CANYON CREEK RANCH

LOCATED IN THE SW 1/4 OF SECTION 14
TOWNSHIP 12 SOUTH, RANGE 66 WEST OF THE 6TH P.M.
STREET IMPROVEMENT PLANS
COUNTY OF EL PASO, STATE OF COLORADO

CANYON CREEK RANCH
COVER SHEET

ALIGNMENT 2 PROFILE (B)
STA 15+25.00 TO 22+65.41

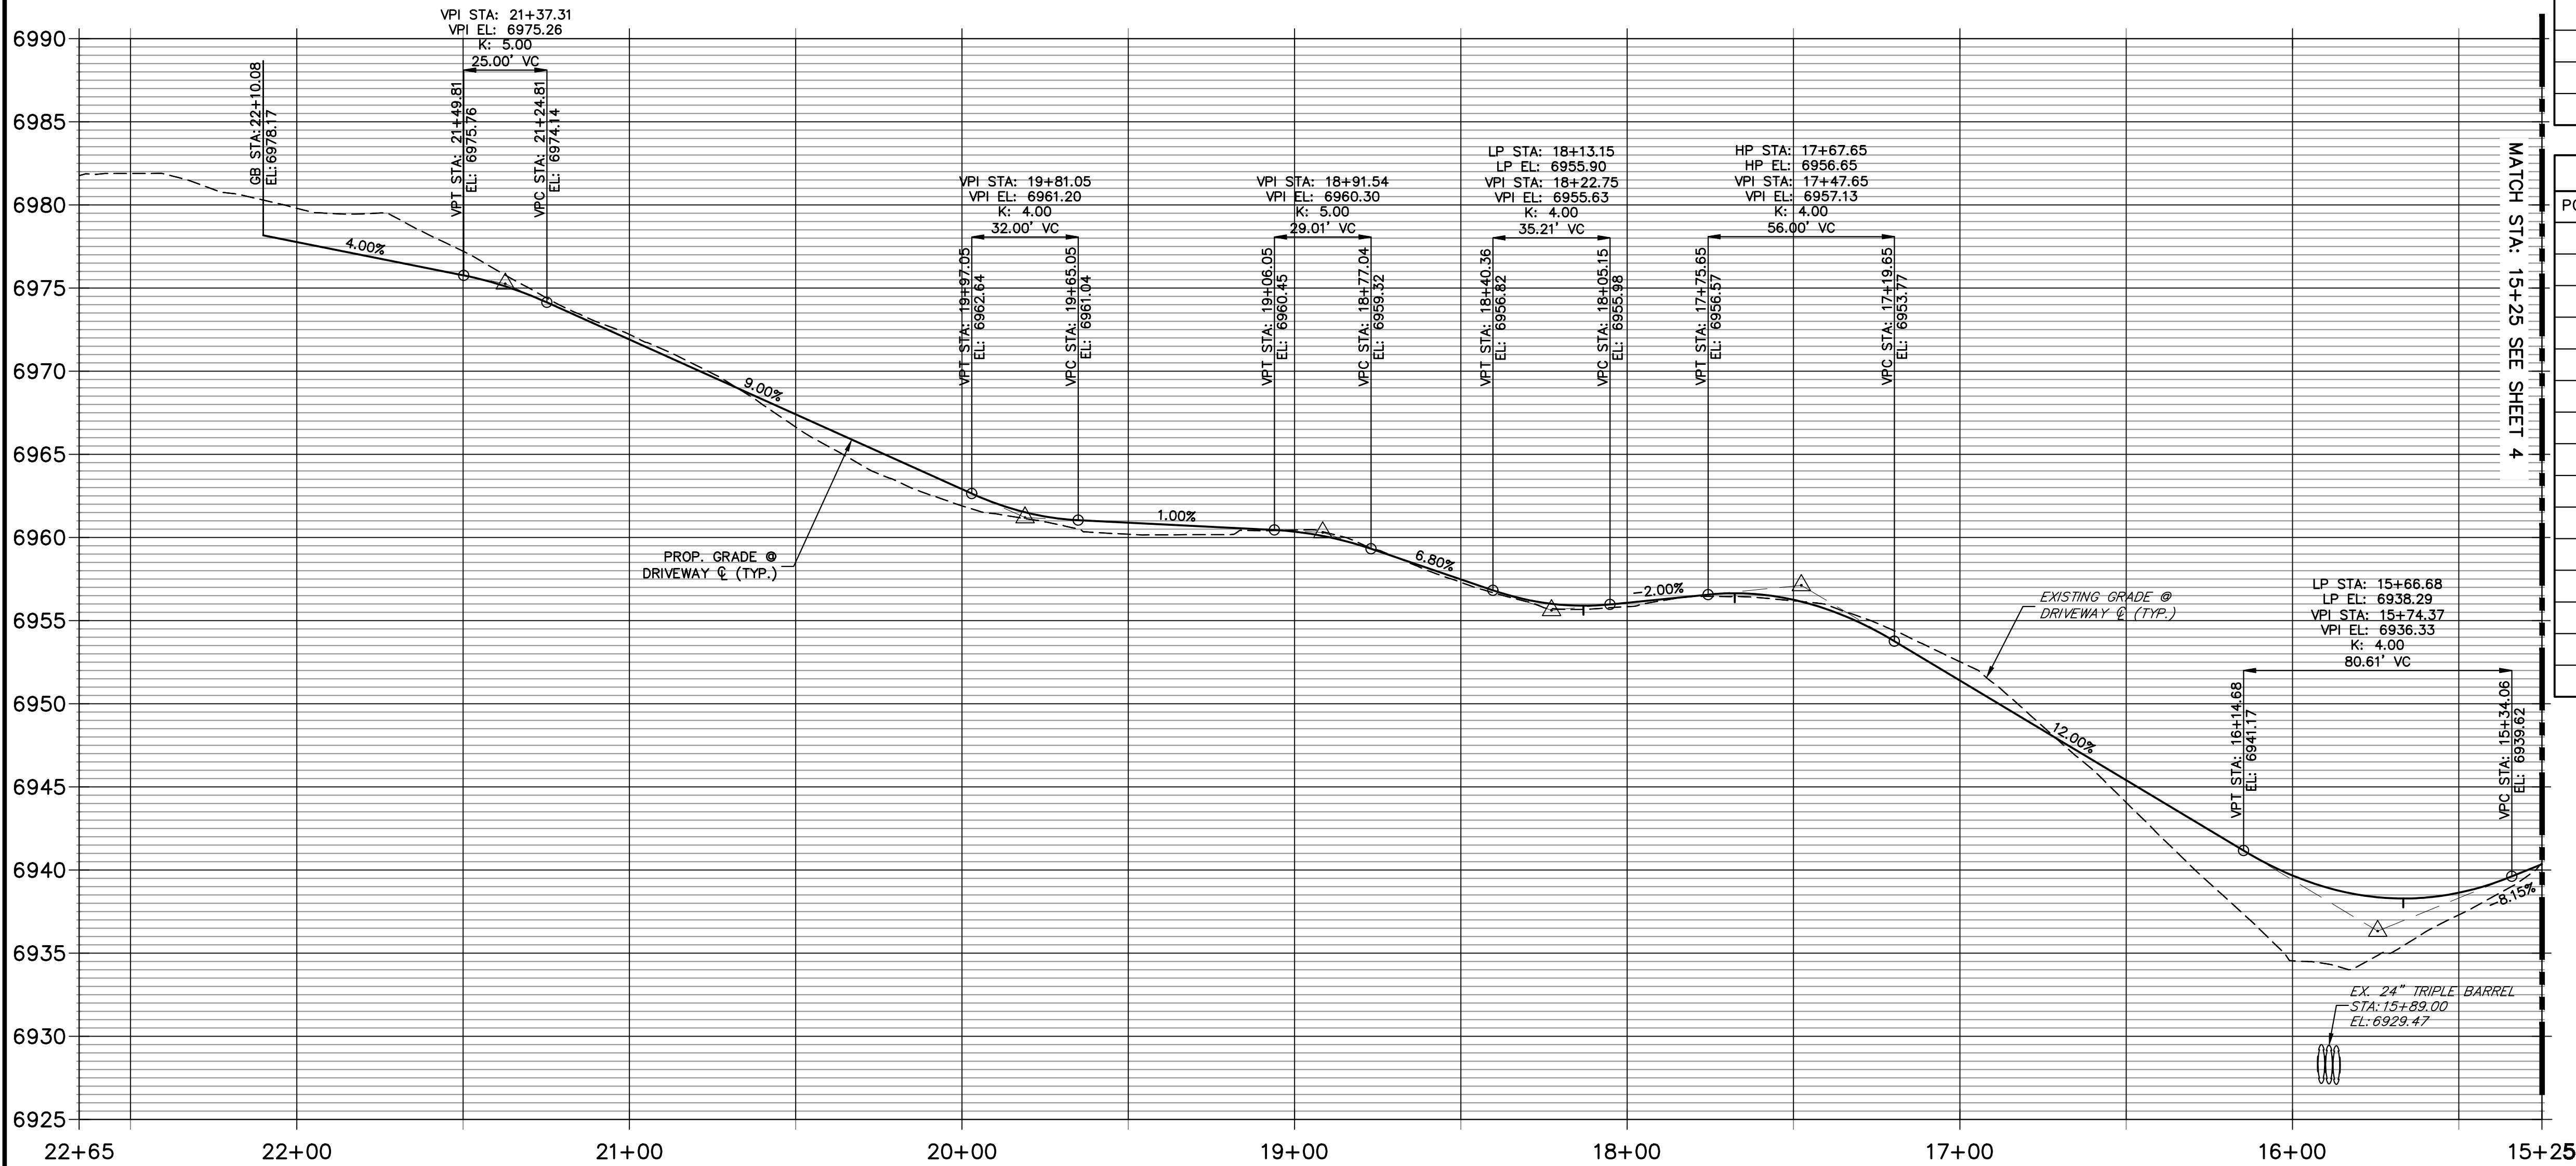
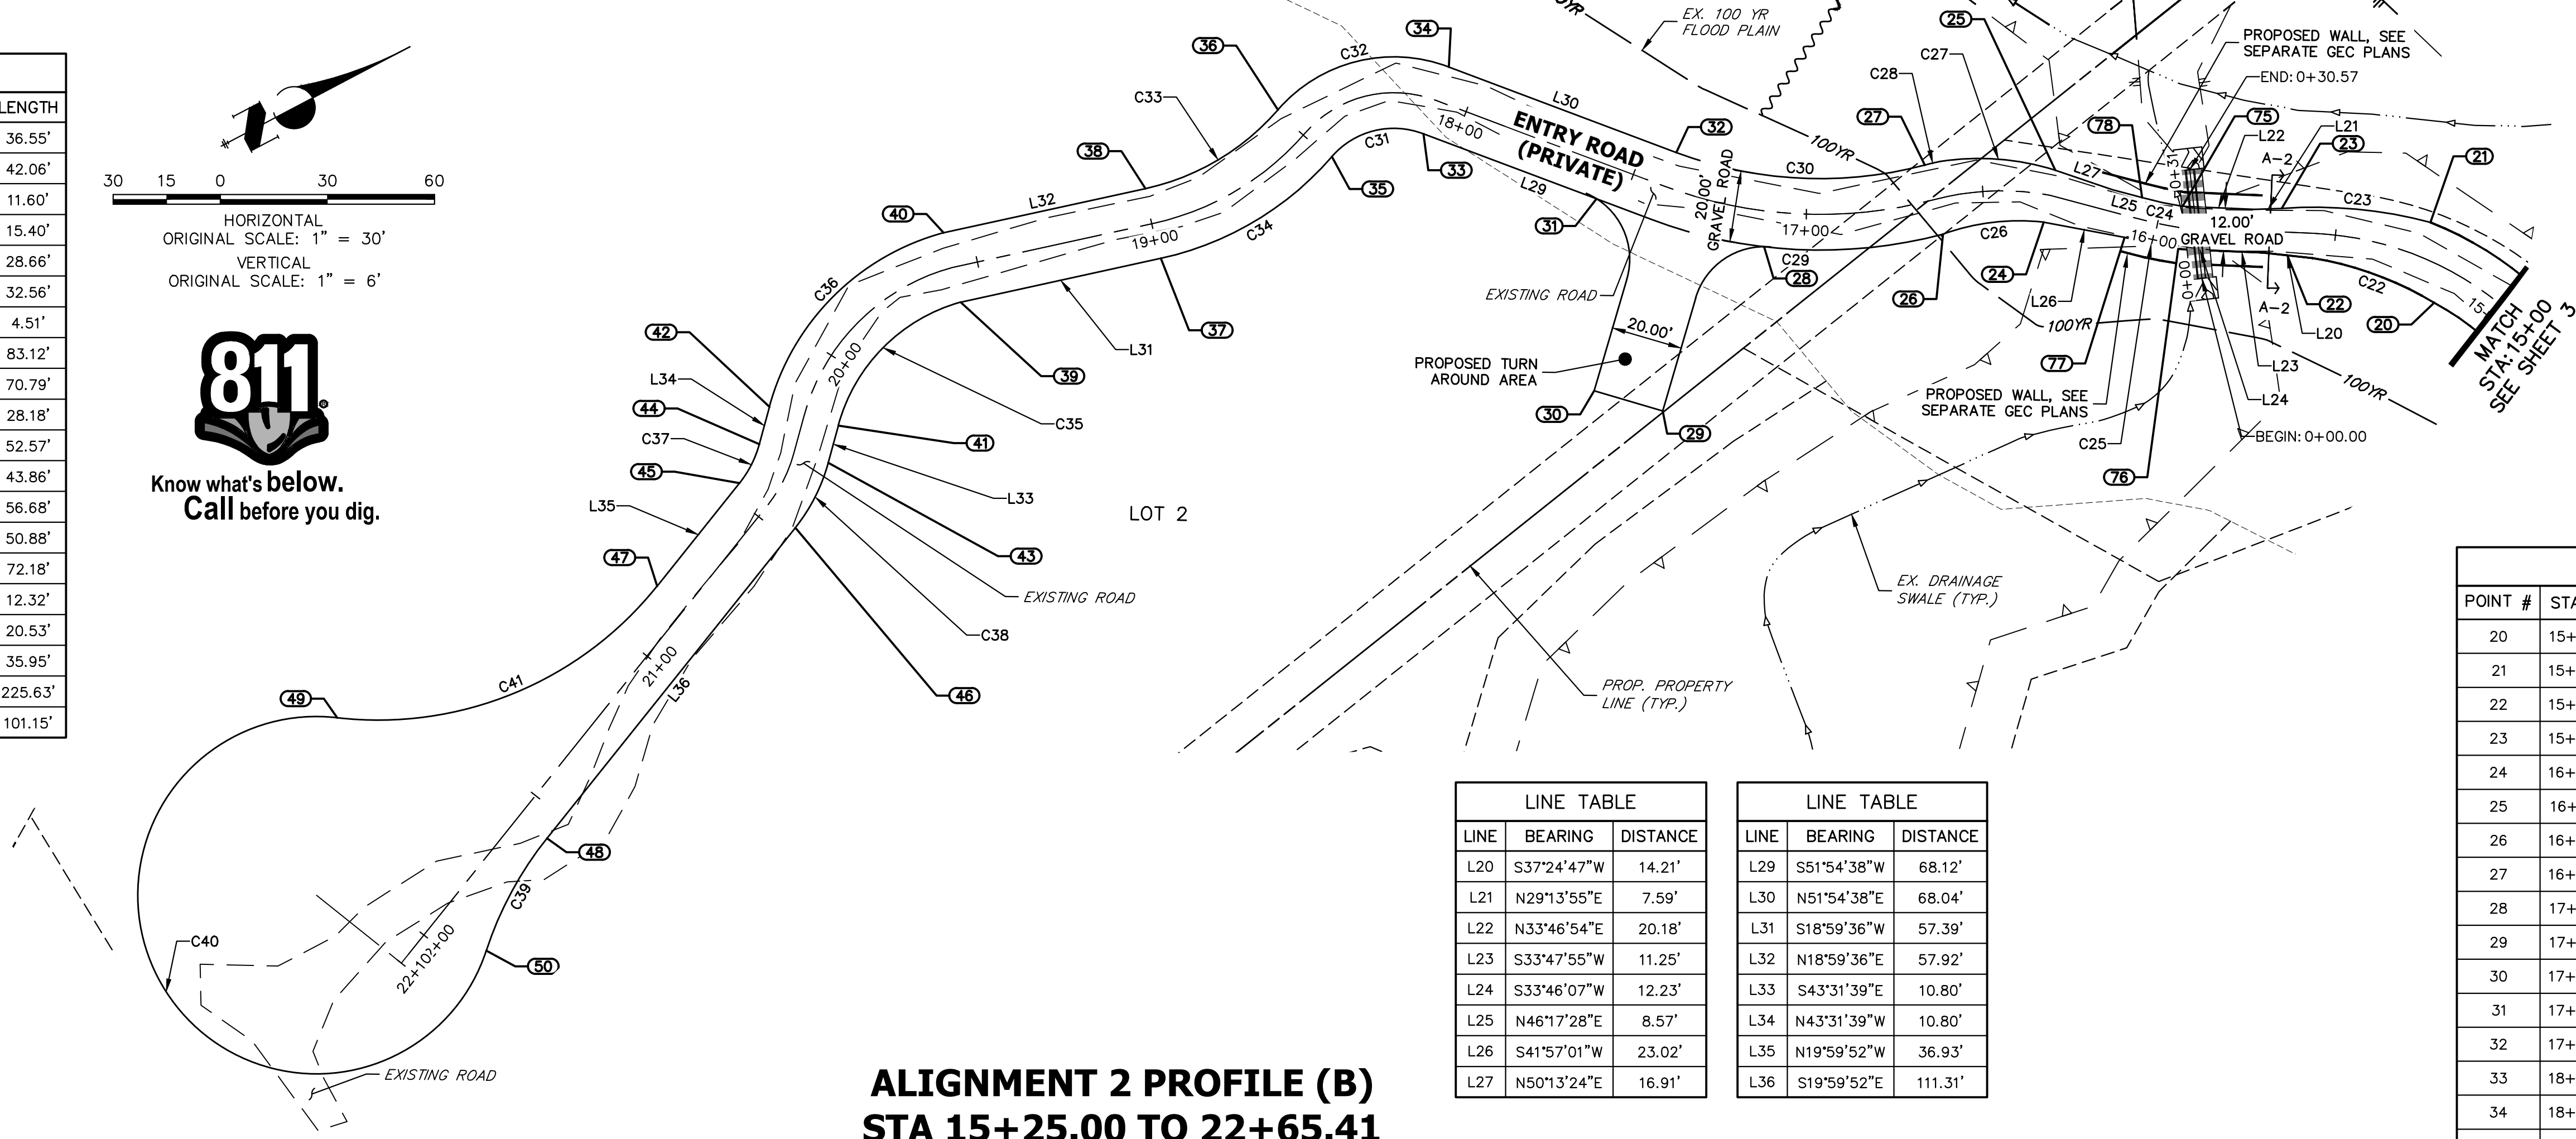
Per the LDC section 6.3.3.C.3 private driveway grade cannot be greater than 12% to provide access to fire department trucks. Revise.
